8th December 2017

Reference: 17765.01FA

**PEER REVIEW OF
PARKING IMPACT ASSESSMENT OF PROPOSED ARTS & CULTURAL PRECINCT
AT PIER 2/3 AND WHARF 4/5. WALSH BAY**

Figure 2.4: Existing traffic volumes by hour

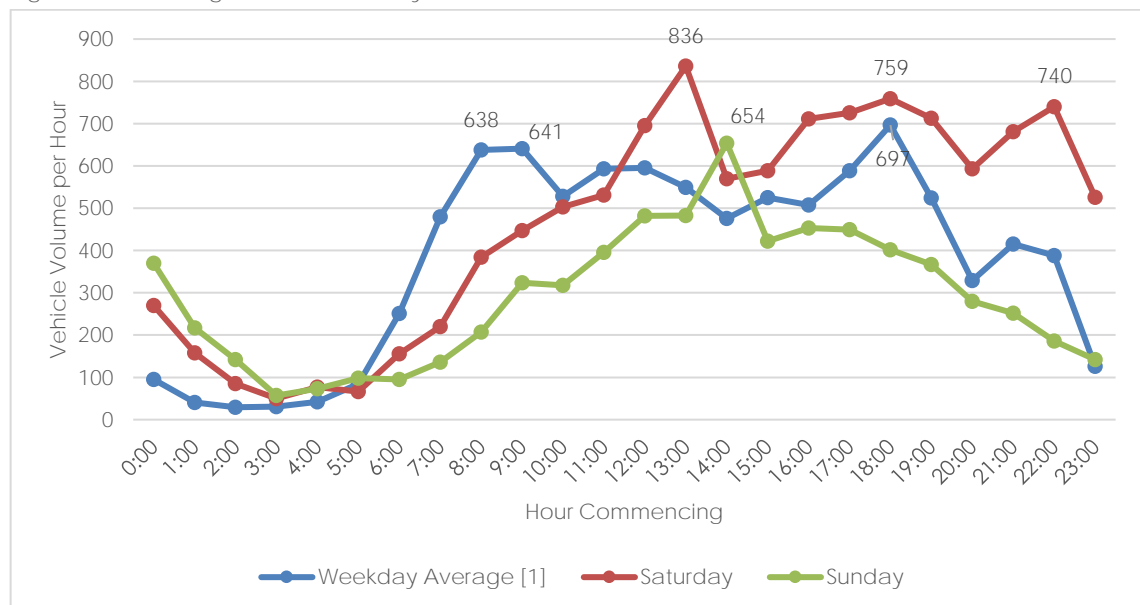
- 1.6 Insufficient justification has been provided for the selection of the days on which the parking occupancy surveys were conducted.
- 1.6.1 Traffic data collected from the automatic tube counts along Hickson Road are incomplete. The tubes were installed to determine the analysis traffic for a full week commencing the 22nd August 2016. but do not provide a complete data set for comparison. No data is provided for Thursday 1st of September 2016 and Friday 2nd September 2016.

- 1.6.2 Due to the lack of data presented it is inappropriate to draw conclusions on when the local traffic peaks occurred during the week of observation.

**Figure 2.11: Hourly parking occupancy**

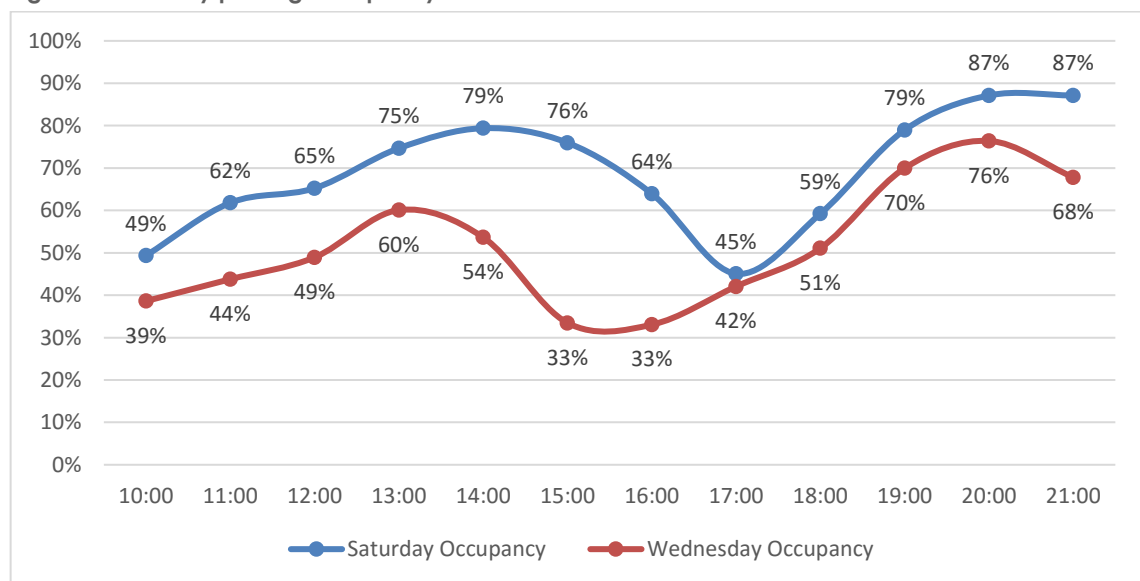
- 1.11 The observation that '*overall demand for parking in the surrounding area is low relative to supply*' is an unsupported and an unjustified conclusion of the local parking supply across all three commercial car parks and on-street parking along Hickson Road.
